Application for a non-material amendment following a grant of planning permission.
Town and Country Planning Act 1990

DEMOLITION OF EXISTING DETACHED AND GARAGE AND ERECTION OF NEW RESIDENTIAL DWELLING AND GARAGE.

M/06/09.

Drawing No: GRJ 64SW 202/B
Item: Revised Porch Roof
Three new porch rooflights
Scale: 1:100
Ref: NMA M/06/09

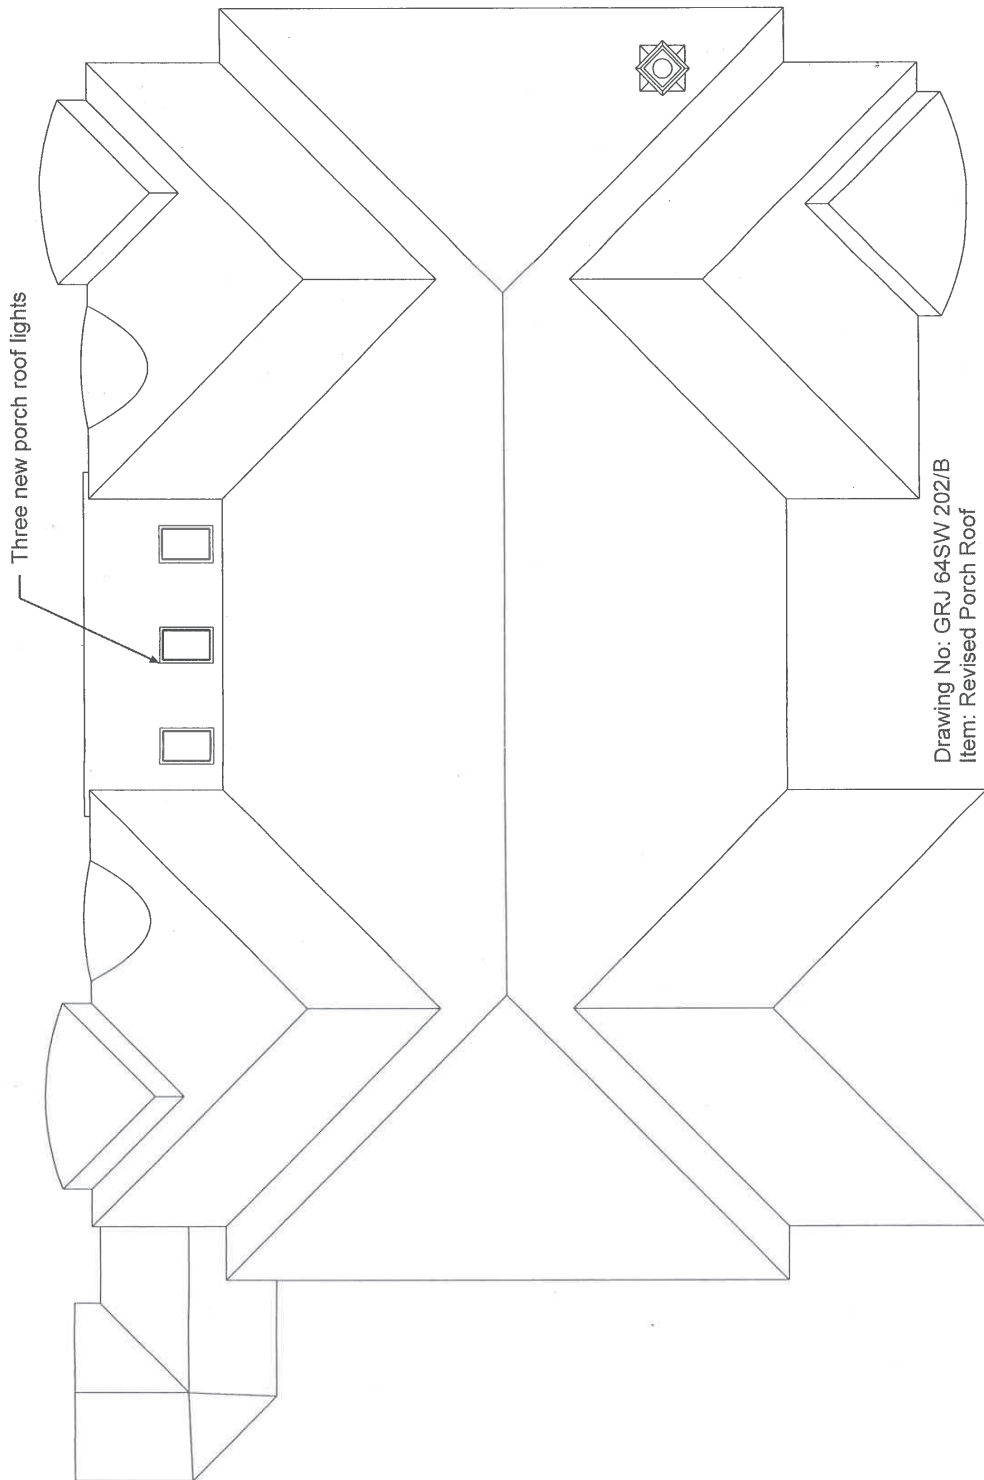
- INSTALLATION OF TWO ROOFLIGHTS ON THE REAR ELEVATION OF THE PROPERTY. THE TWO ROOFLIGHTS EACH MEASURE 550MM X 978MM. EXTERNAL VIEWS THROUGH THE ROOFLIGHTS ARE NOT POSSIBLE.
- INSTALLATION OF THREE ROOFLIGHTS ON THE PORCH ROOF ON THE FRONT ELEVATION OF THE PROPERTY. THE THREE ROOFLIGHTS EACH MEASURE 660MM X 1178MM. EXTERNAL VIEWS THROUGH THE ROOFLIGHTS ARE NOT POSSIBLE.
